lower reaps farm - barn

design statement
planning application

june 2025

'Conversion of barn to create new dwelling. Construction of garage block. Demolition of existing farm building'.

project	project number	drawing number
lower reaps farm - barn	24.50	pl.11
name		
proposed - plans		
scale	date	status
1 to 100 @ A1	may 24	planning
		revision
		A

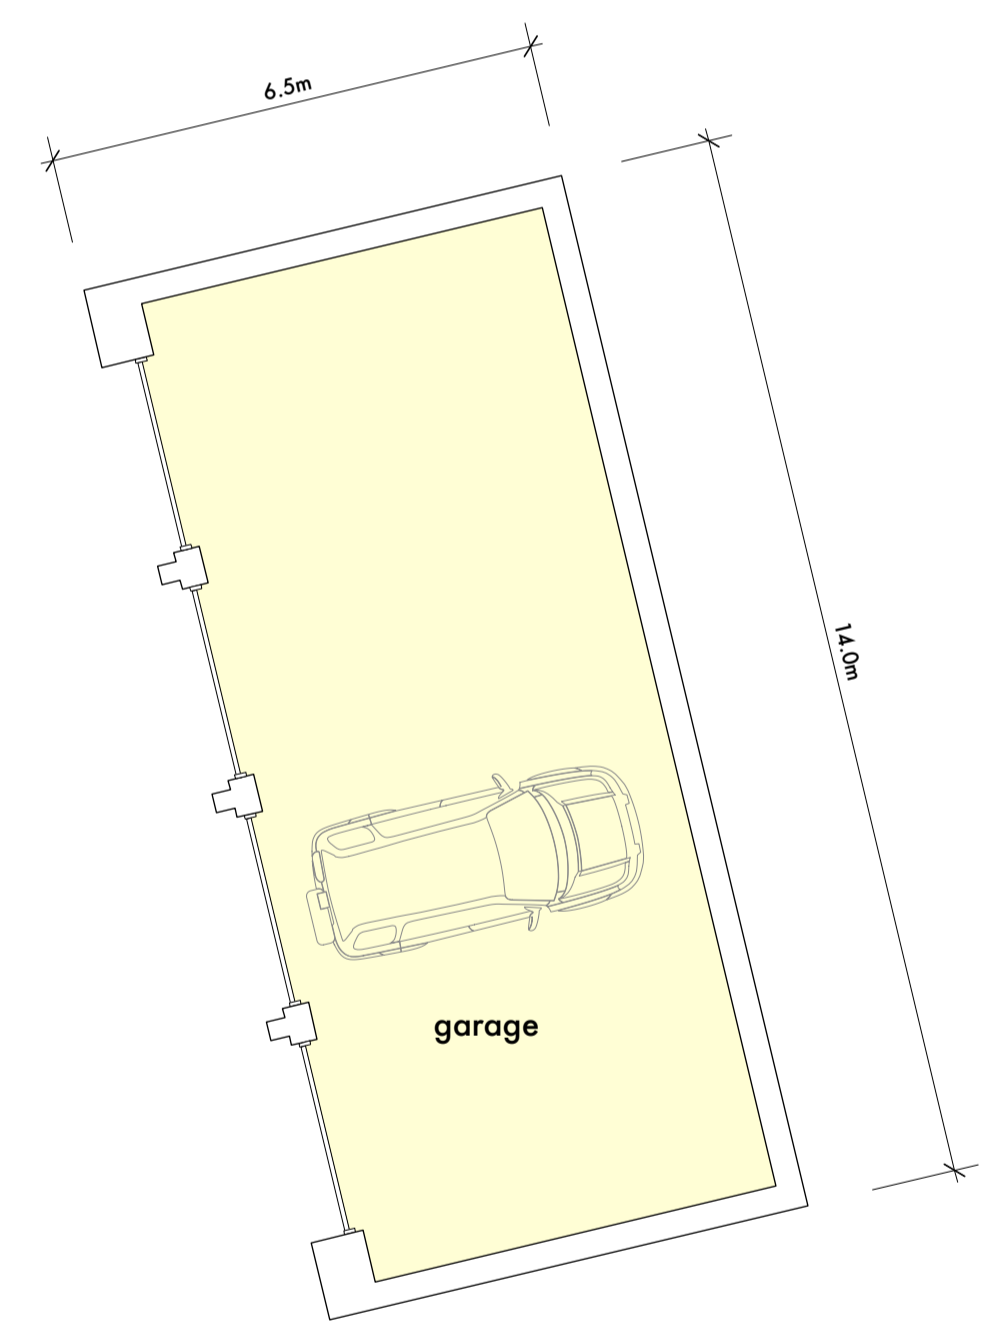
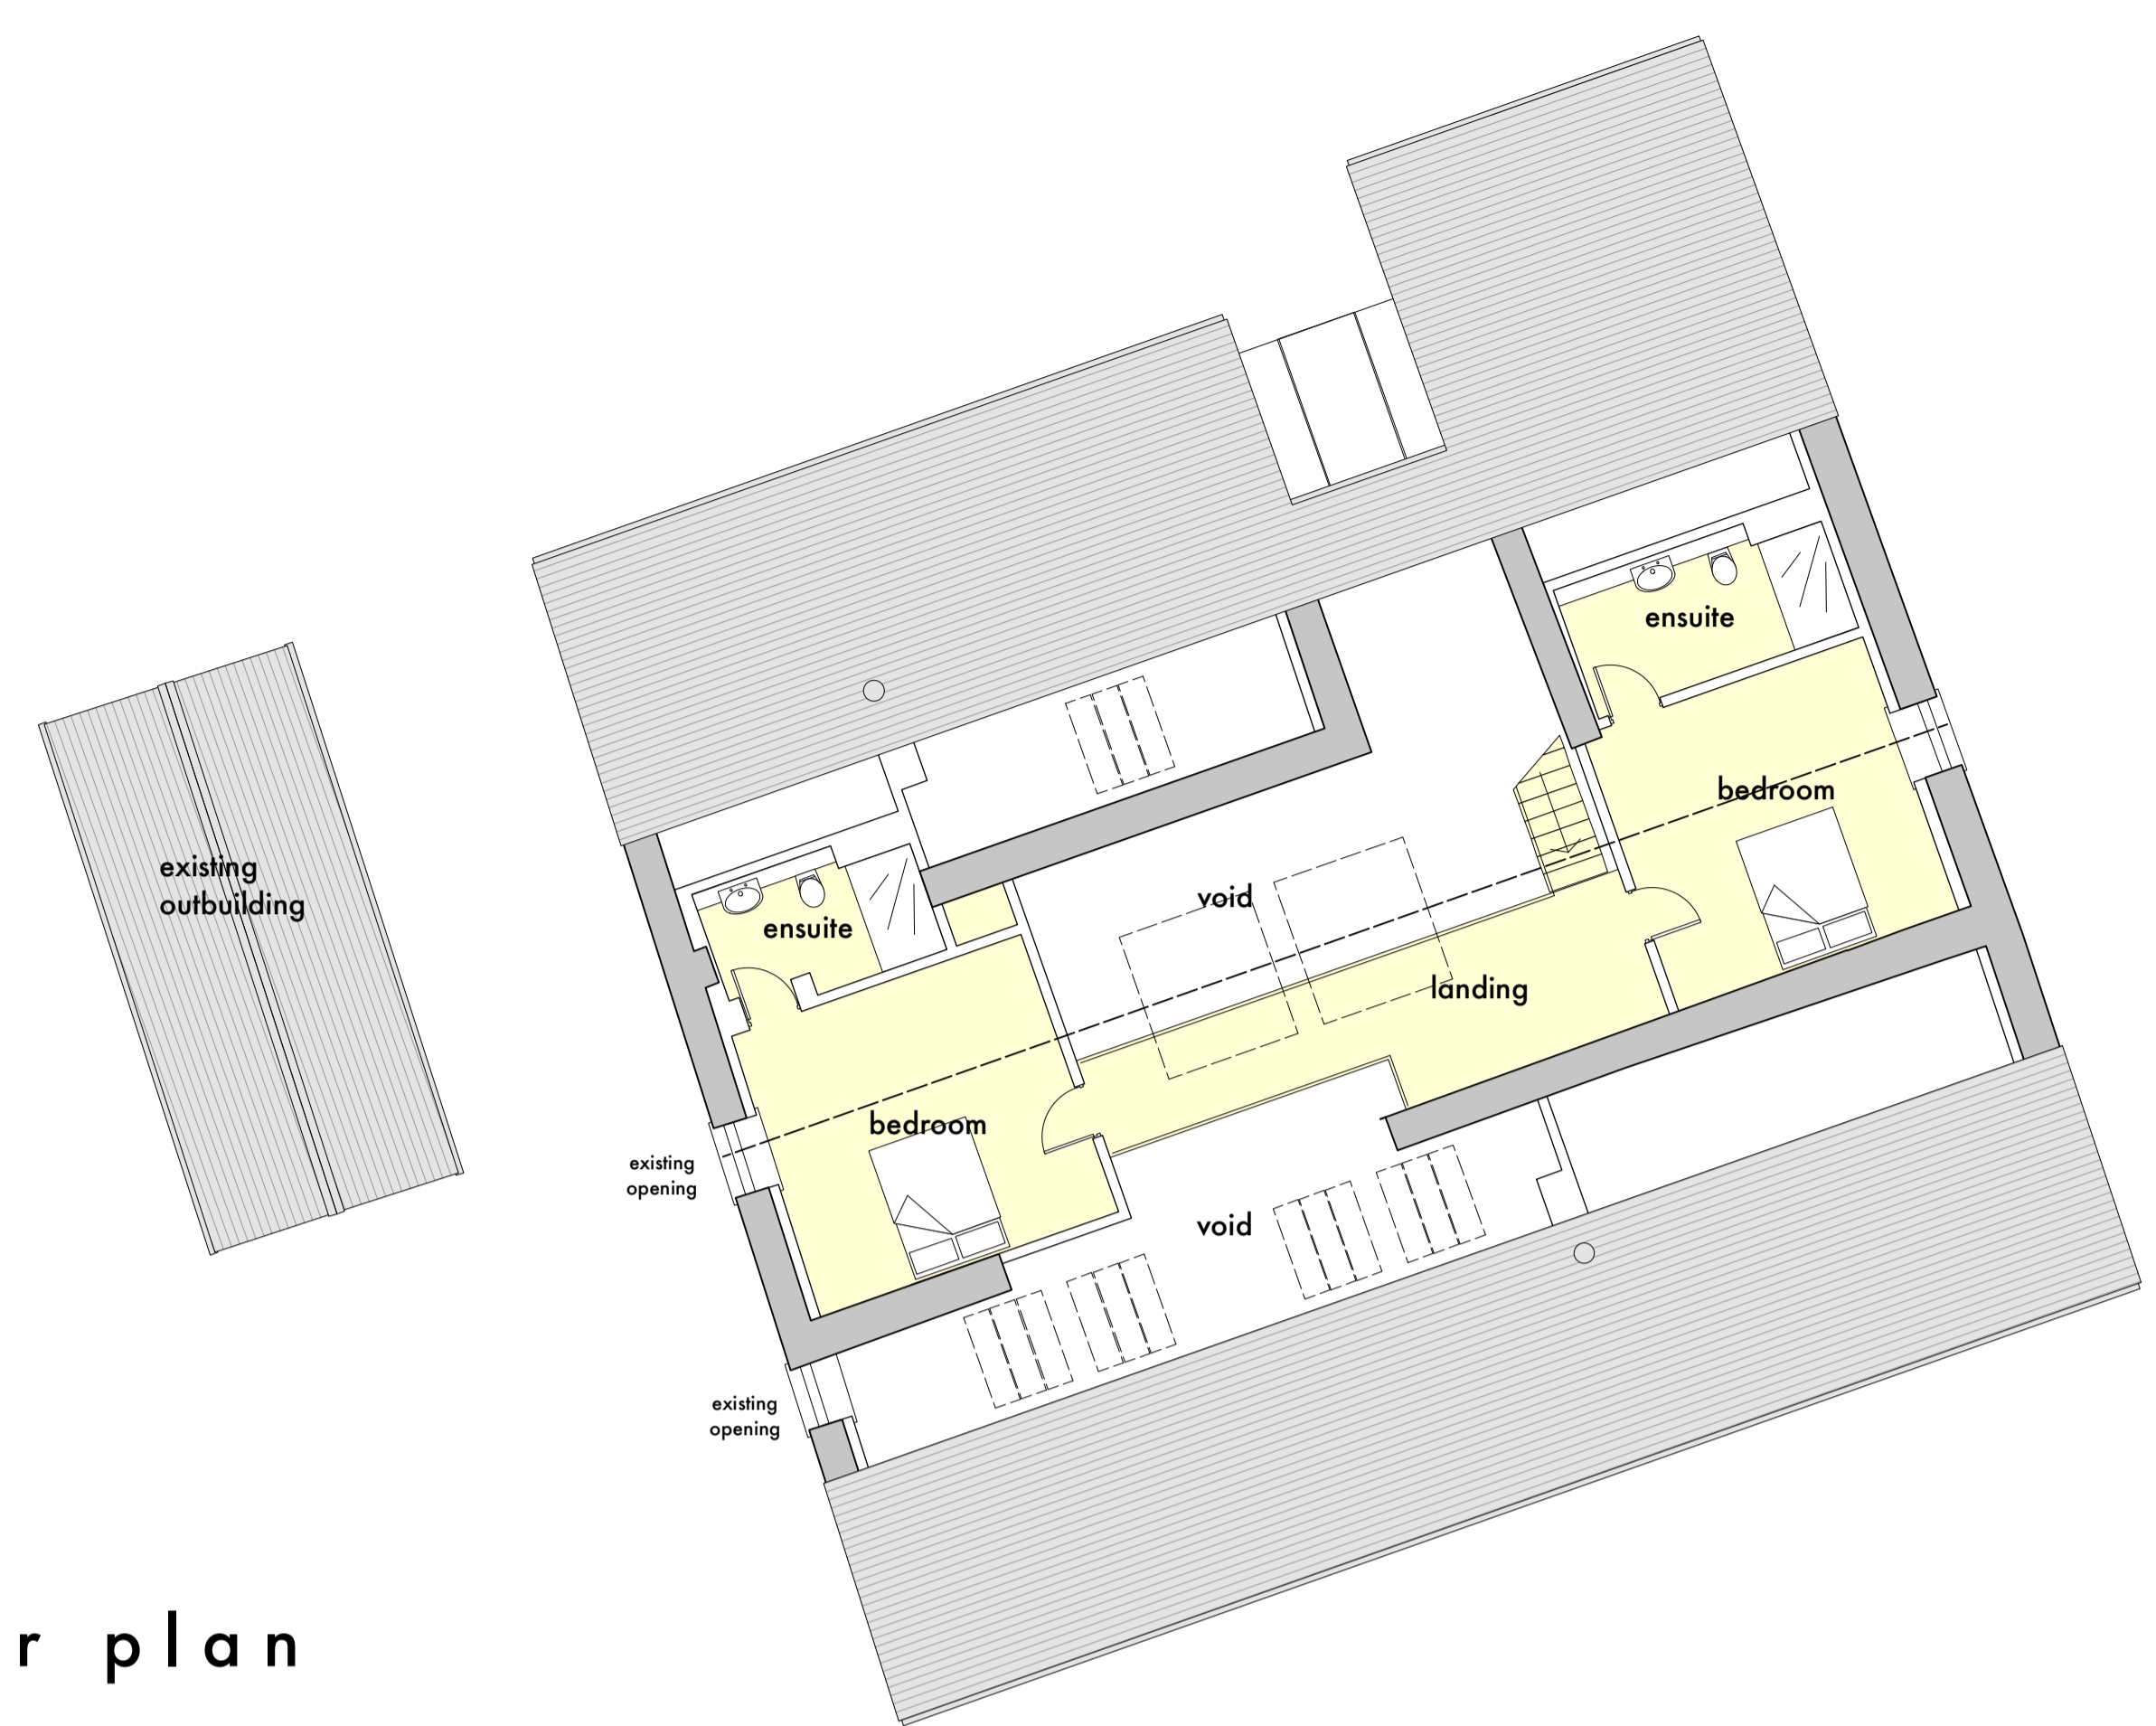
5.3 *"No scaled floorplans have been provided to enable the Planning Officer to assess the size of the dwelling in terms of internal layout".*

5.9 *"It is noted that part of the ground floor wall between the proposed sitting room and kitchen/family room would be removed".*

Action The previous approved scheme (ref.3/2022/1165 and 1166) for the conversion of the barn created 2no units - this was deemed to have satisfied this matter. The current submission includes scaled floorplans of the proposals which create a single dwelling.

Action It is noted that the current proposals allow for more of this internal wall to be retained than the previously approved scheme.

north elevation

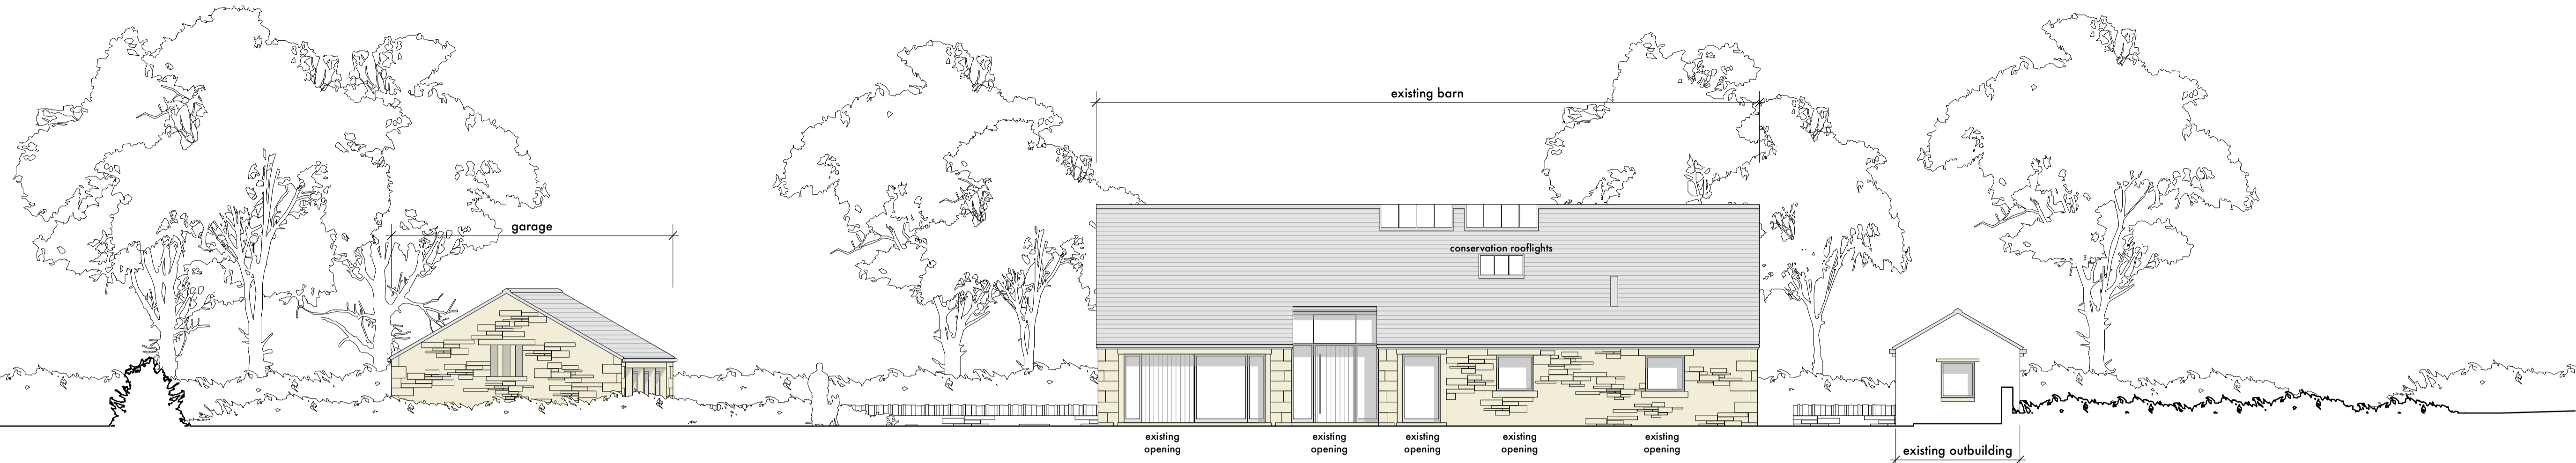
5.11 *"The proposals would include alterations to the proposed rooflights which would not be sited closer together to the northern roof in a linear pattern The siting of the rooflights compared to the approved scheme would be more visually prominent ... conservation rooflights should be proposed rather than a continuous linear pattern".*

- A Existing opening to be partially glazed and boarded. The pre-application refers to the previous approved application which allowed for the whole of the existing opening to be glazed. The current proposal follows this accepted principle however introduces partial infill boarding referencing the traditional Yorkshire boarding vernacular.
- B Existing main cart entrance is retained and used as the main entrance to the property.
- C Existing doorway
- D Existing window opening
- E Existing window opening
- F Conservation rooflights

Action The proposed rooflights are now configured in the suggested 'scattered' arrangement. Rooflights will be 'conservation' type lying closer to the roof plane. The ridge light, providing natural light to the heart of the plan, has been split and reduced in size.

south elevation

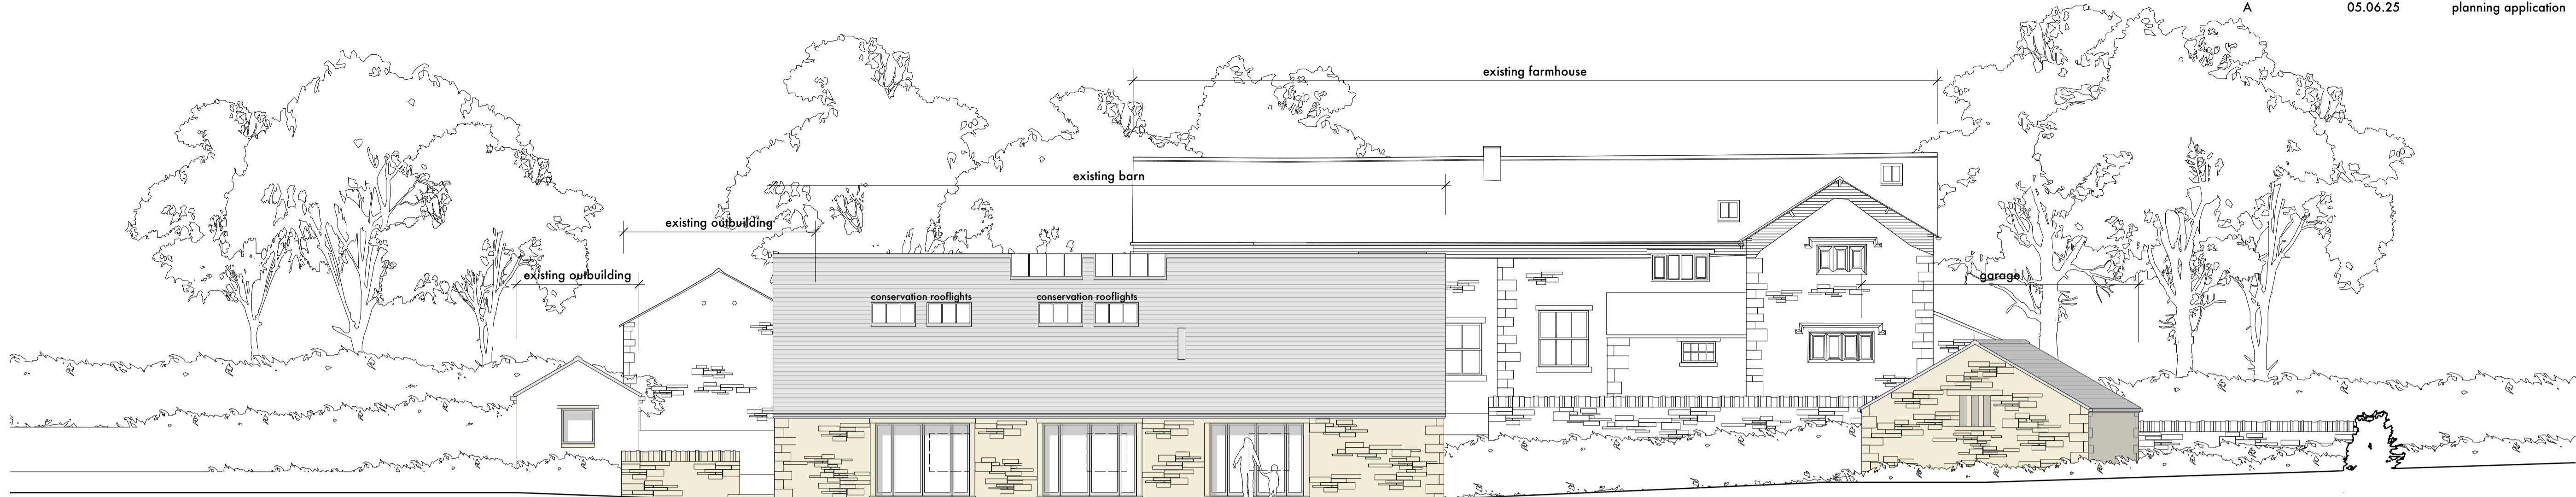
5.10 *"Whilst the southern elevation may need to be rebuilt, the large openings proposed are not already in-situ and it is considered that these would likely harm the historic character of the barn".*

- A Proposed opening to provide access from living accommodation to garden - see section 5.10.
- B As opening 'A'
- C As opening 'A'
- D Conservation rooflights

Action The rebuilding works are noted in item no.2. The proposed openings are required to provide access from the living accommodation to the garden. The current proposals allow for less of the southern wall to be rebuilt than suggested in the pre-application submission. The proposed opening sizes have been noticeably reduced in size compared to the pre-application submission (20% reduction).
